Subject: Ground Floor Flat 47 Horsham Road Littlehampton BN17 6DB - LU/12/21/PL

Planning Application Reference: LU/12/21/PL

Proposal: Change of use from 1 No.dwelling (C3 Dwelling House) to Beauty Salon (Sui Generis).
This site is in CIL Zone 4 (Zero Rated) as other development.

EXISTING BUILDING

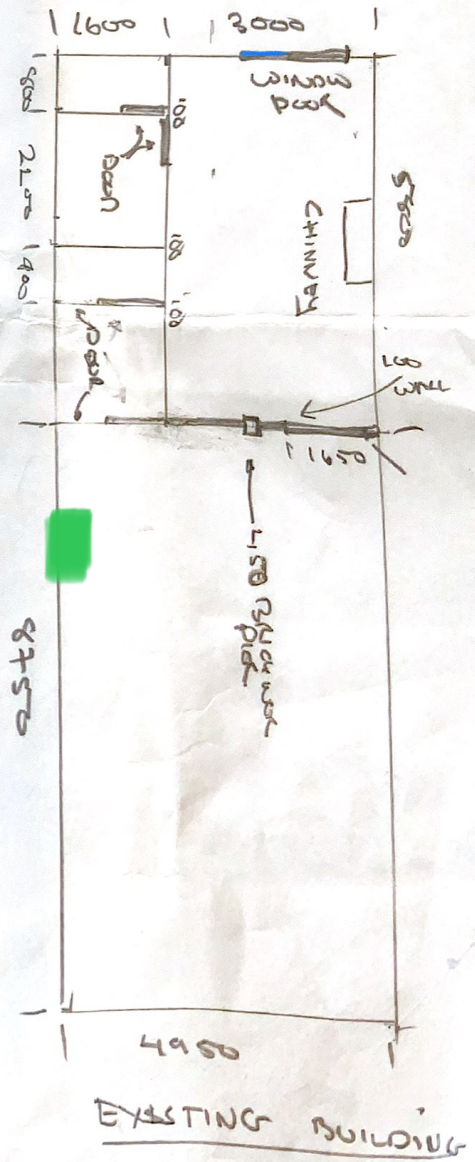
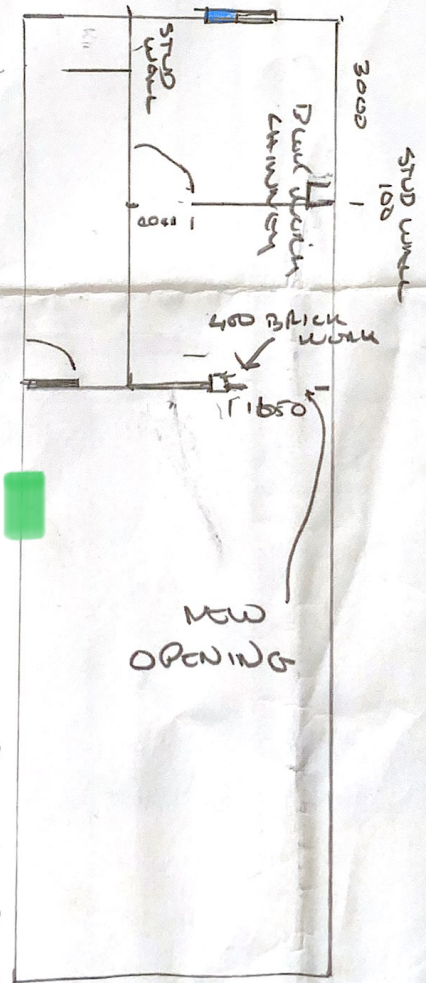
The sound insulation of the floor / ceiling between the ground and first floor shall achieve a minimum airborne sound insulation value of 50 dB ($D_{nT,w} + C_{tr}$). Before the commercial unit is operational, a test shall be undertaken by a competent acoustician and submitted to the Local Planning Authority to demonstrate compliance with this level.
